**Consultation Response from KC,
Highways Development Management**

2024/90602 Bryan Wood Residential Home, 1, Bryan Road, Edgerton, Huddersfield, HD2 2AL

Discharge conditions 3 (boundary fencing), 5 (cycle storage), 7 (Arboricultural Method Statement), 11 (bat and bird box) on previous permission 2022/92581 for change of use from residential care home (Class C2) to a school (Class F1(a)) (within a Conservation Area)

Date Responded: 01/05/2024.

DWG No: 1.0

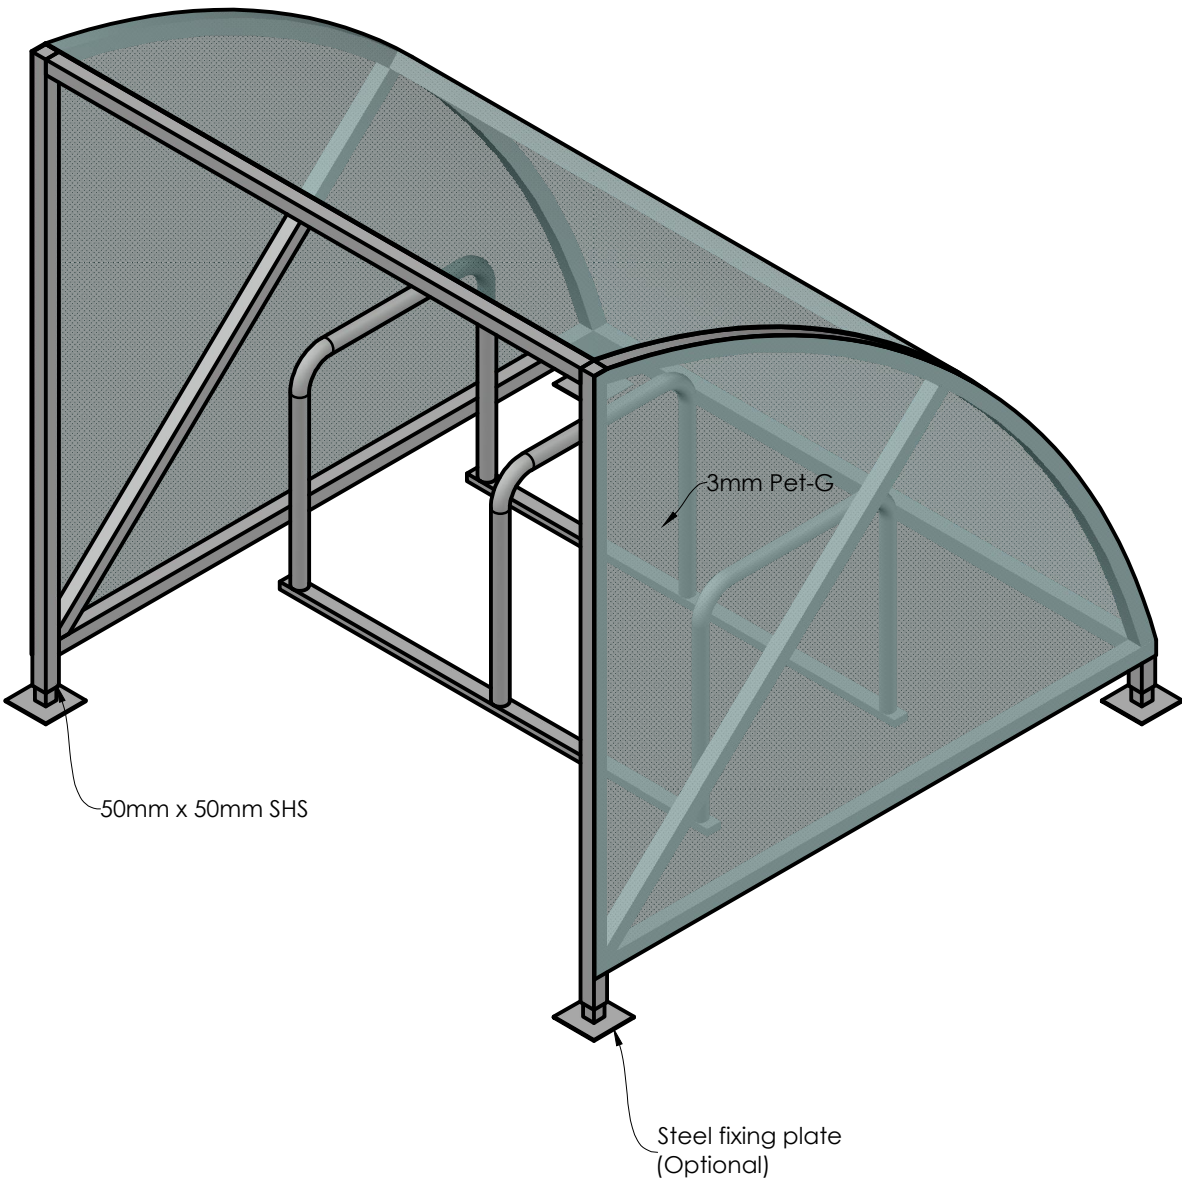
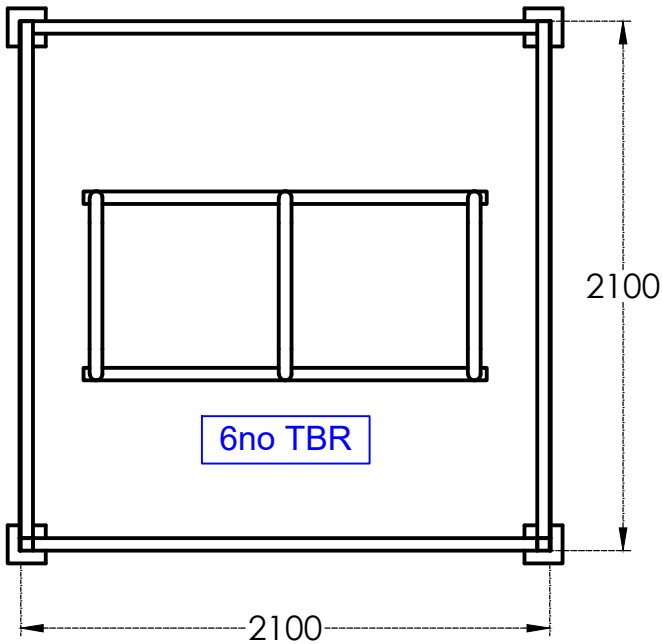
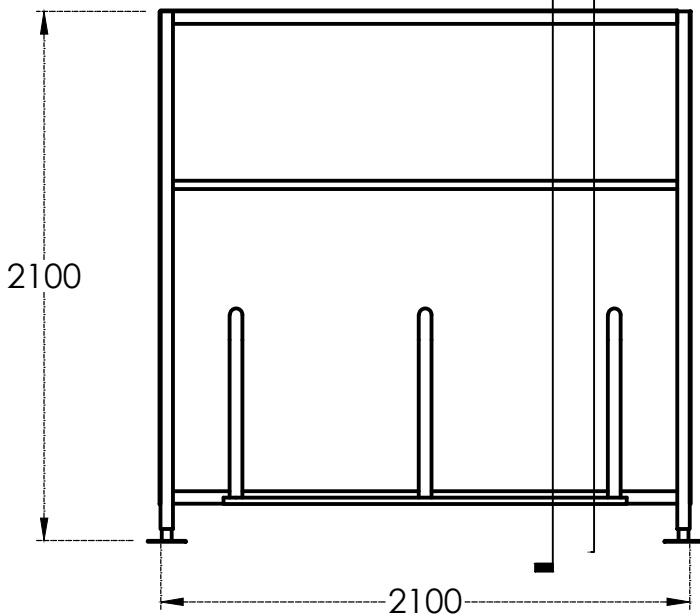
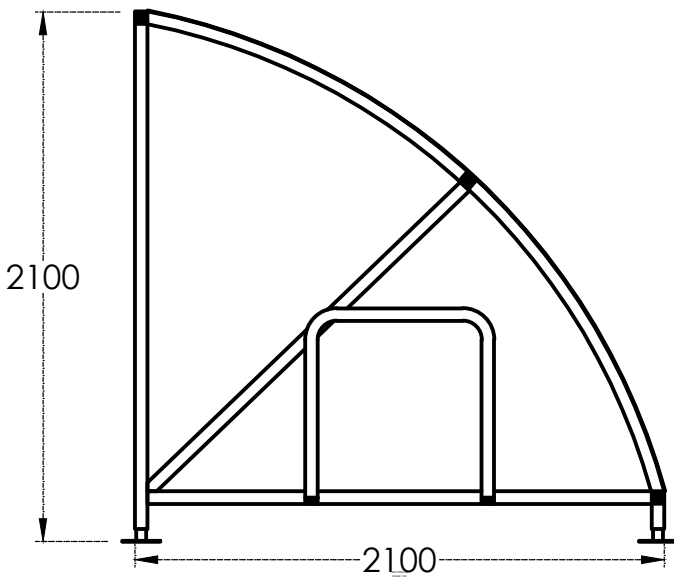
Drawing No WAL-22-27-02G has identified a suitable location for the cycle shelter and Drawing No 1.0 from the Bike Shelter Company specifies the type of shelter to be provided.

The drawings as submitted are therefore acceptable and condition 5 can be discharged.
